A46 Newark Bypass

Scheme Number: TR010065

**Statement of Common Ground with
Nottinghamshire County Council**

Regulation Number:	8(1)(e)
Planning Inspectorate Scheme Reference	TR010065
Application Document Reference	7.26
Author:	A46 Newark Bypass Project Team, National Highways

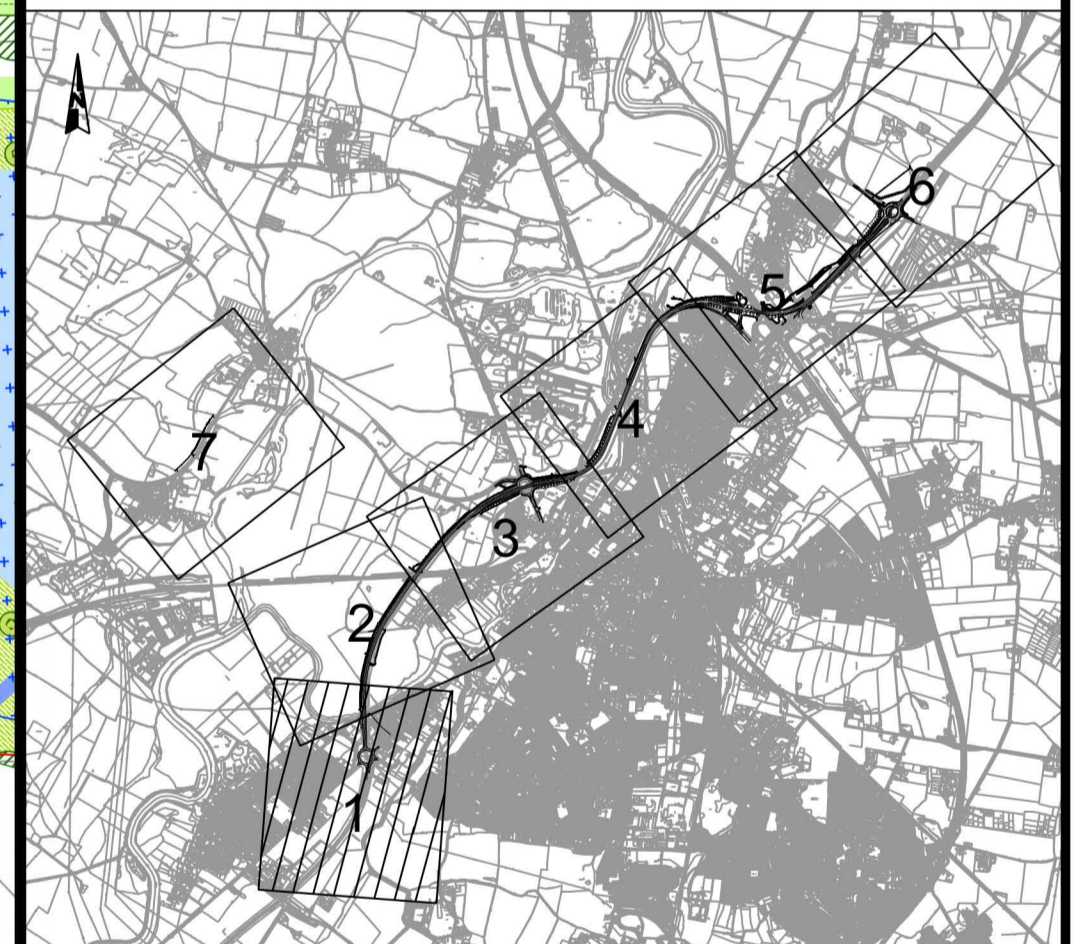
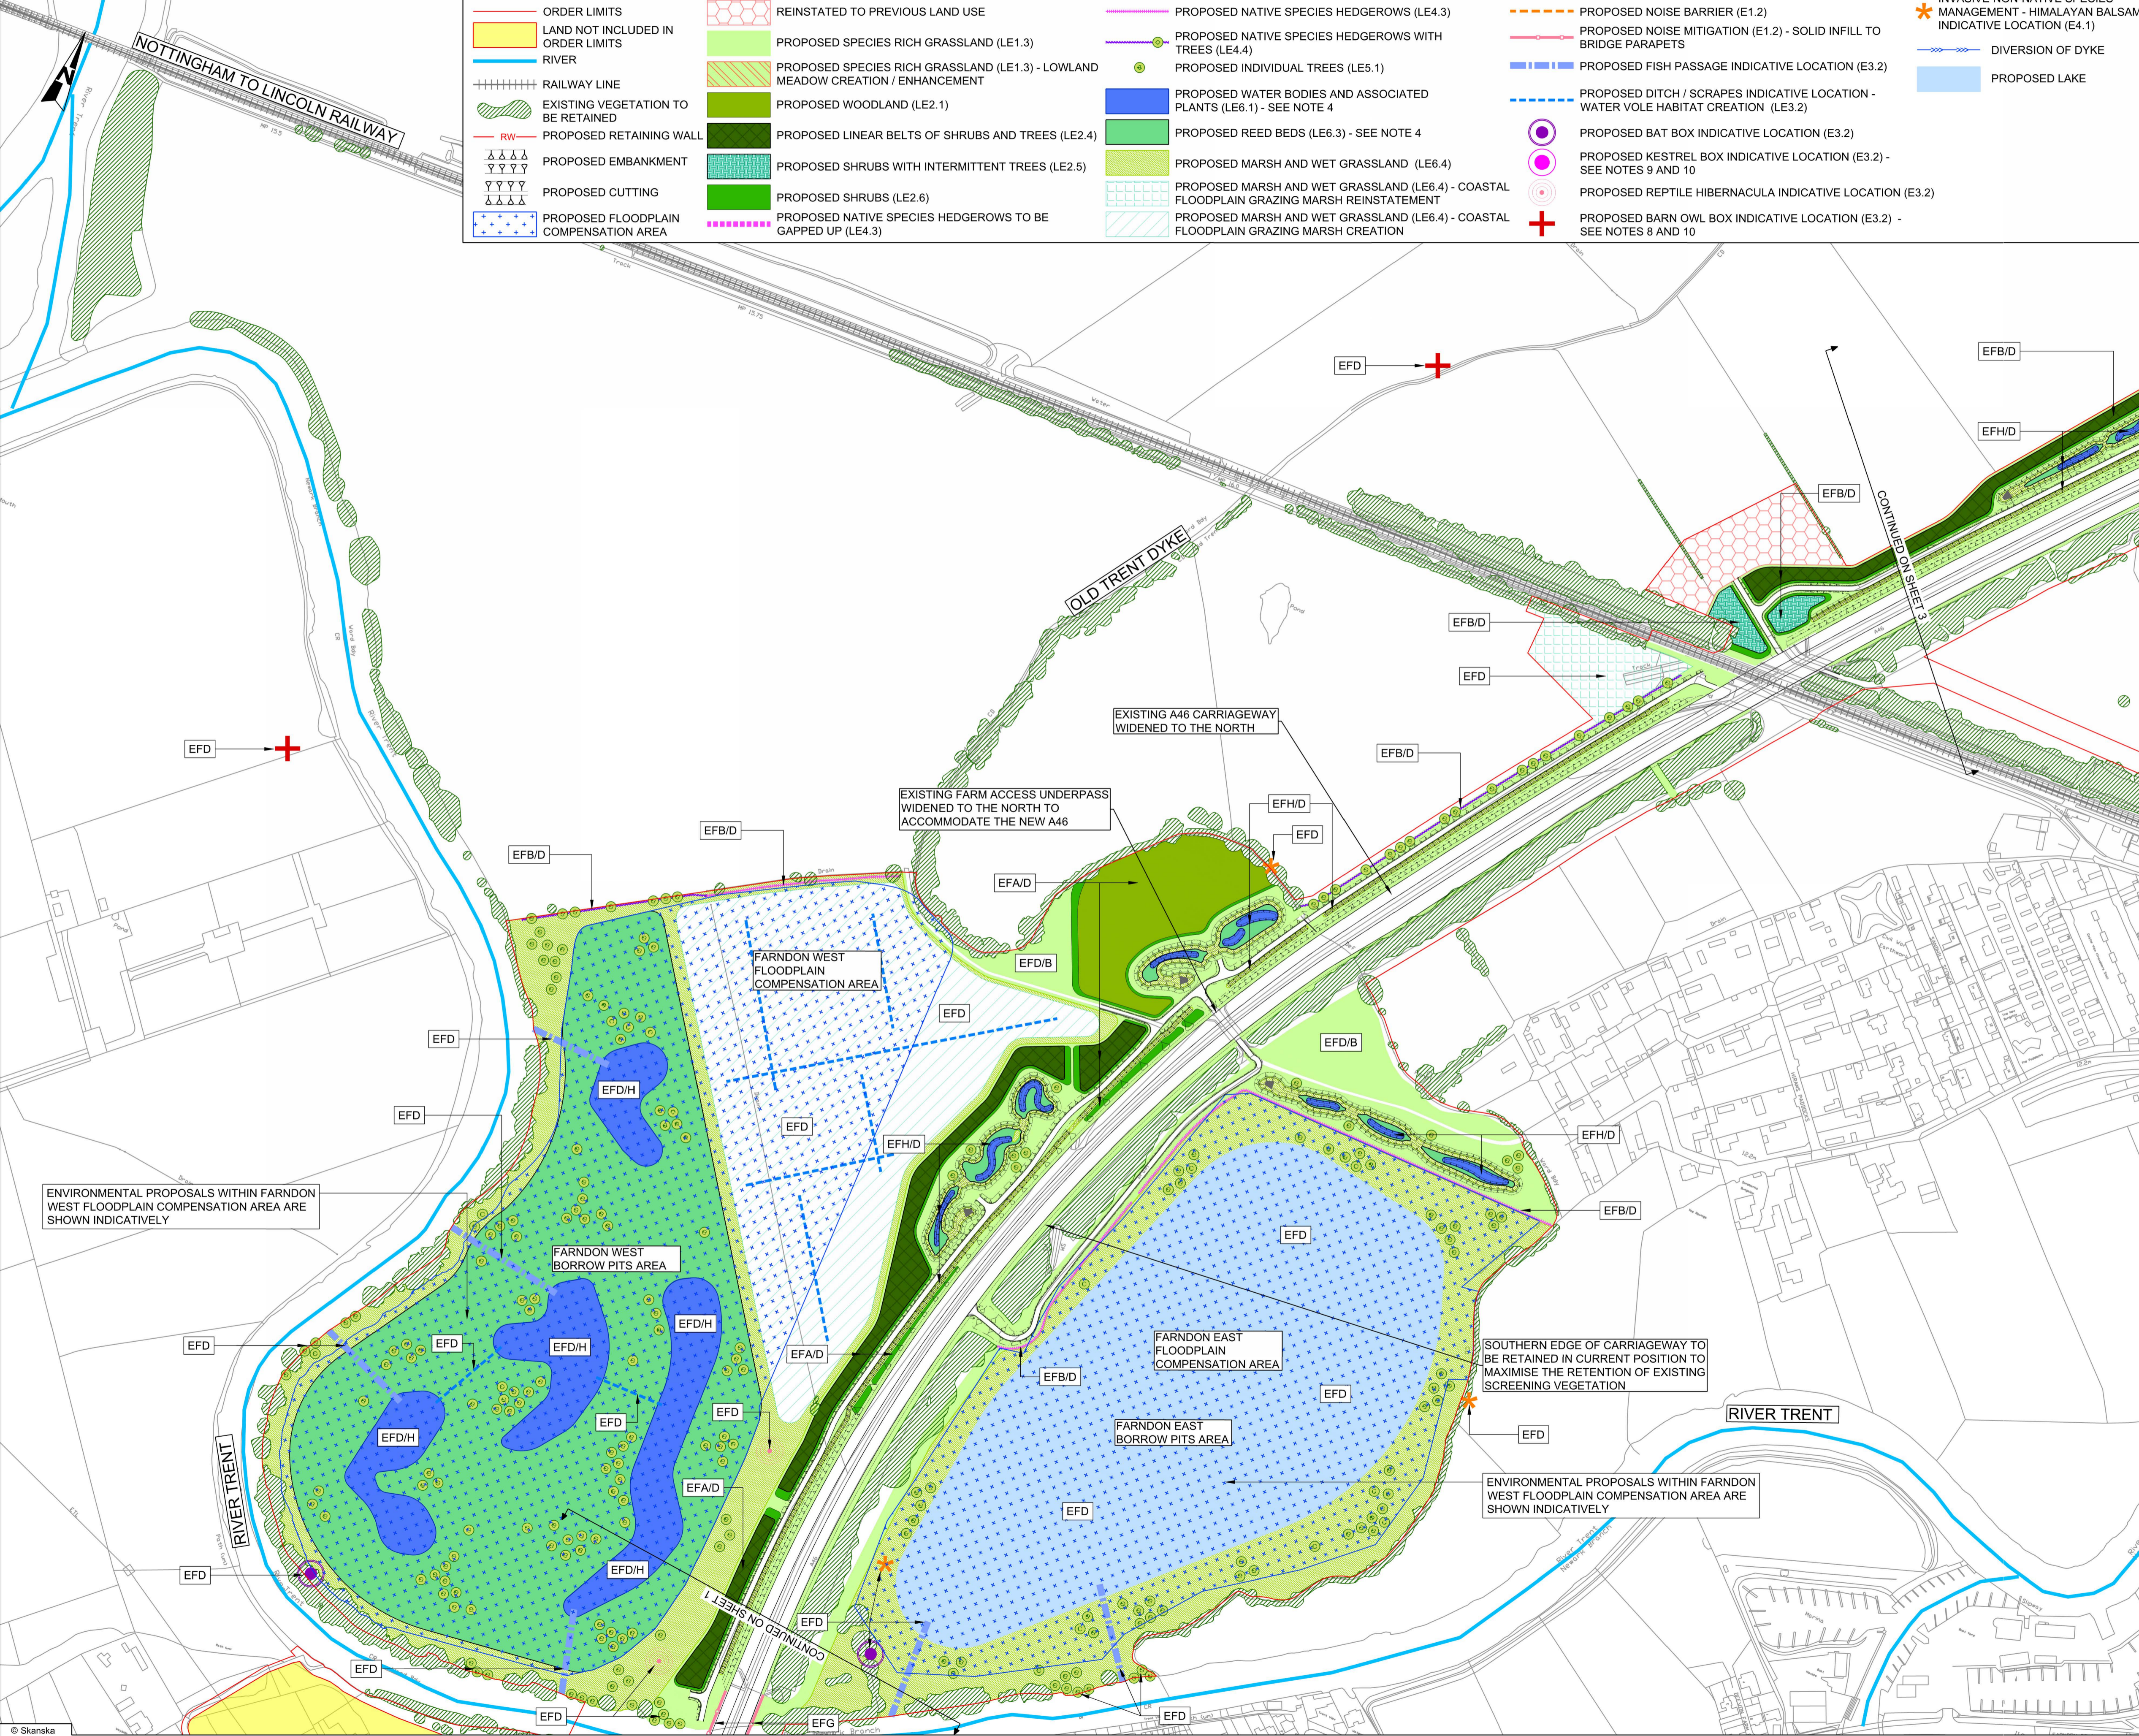
5.	PRoW		<p>Farndon A46 roundabout</p> <p>The plans indicate that the Farndon Underpass will remain open throughout the works which is good. As you are aware the land adjacent to Crees Lane is currently used by members of the public as a walking route, we are also aware that National Highways are planning to use this as a compound. We would support the opportunity to create a public footpath at this location to link the underpass with Footpath No.5 and Bridleway No.2.</p> <p>Farndon A46 roundabout - the land which is set out for the works compound adjacent to Crees Lane has a number of unrecorded desire lines through it. It would be advantageous to see these formally recorded and set out following completion of the Scheme.</p>	<p>Following feedback received as part of the statutory consultation, the temporary diversion of bridleway BW2 was changed, and an alternative route was presented as part of the targeted consultation on the Scheme between 14 March and 16 April 2023. Following further feedback received as part of the targeted consultation the temporary diversion of the bridleway will be only for use by equestrians. Pedestrians and cyclists will utilise the existing footpath FP5 from the River Trent to gain access to the route adjacent to Crees Lane shown within the Order Limits.</p> <p>The unrecorded desire lines are on a piece of land that has been identified for temporary use as part of Scheme, any activity to formally record these desire lines as Public Rights of Way would need to be undertaken by stakeholders, including NCC, outside of the Scheme.</p>	Agreed	04/11/2024
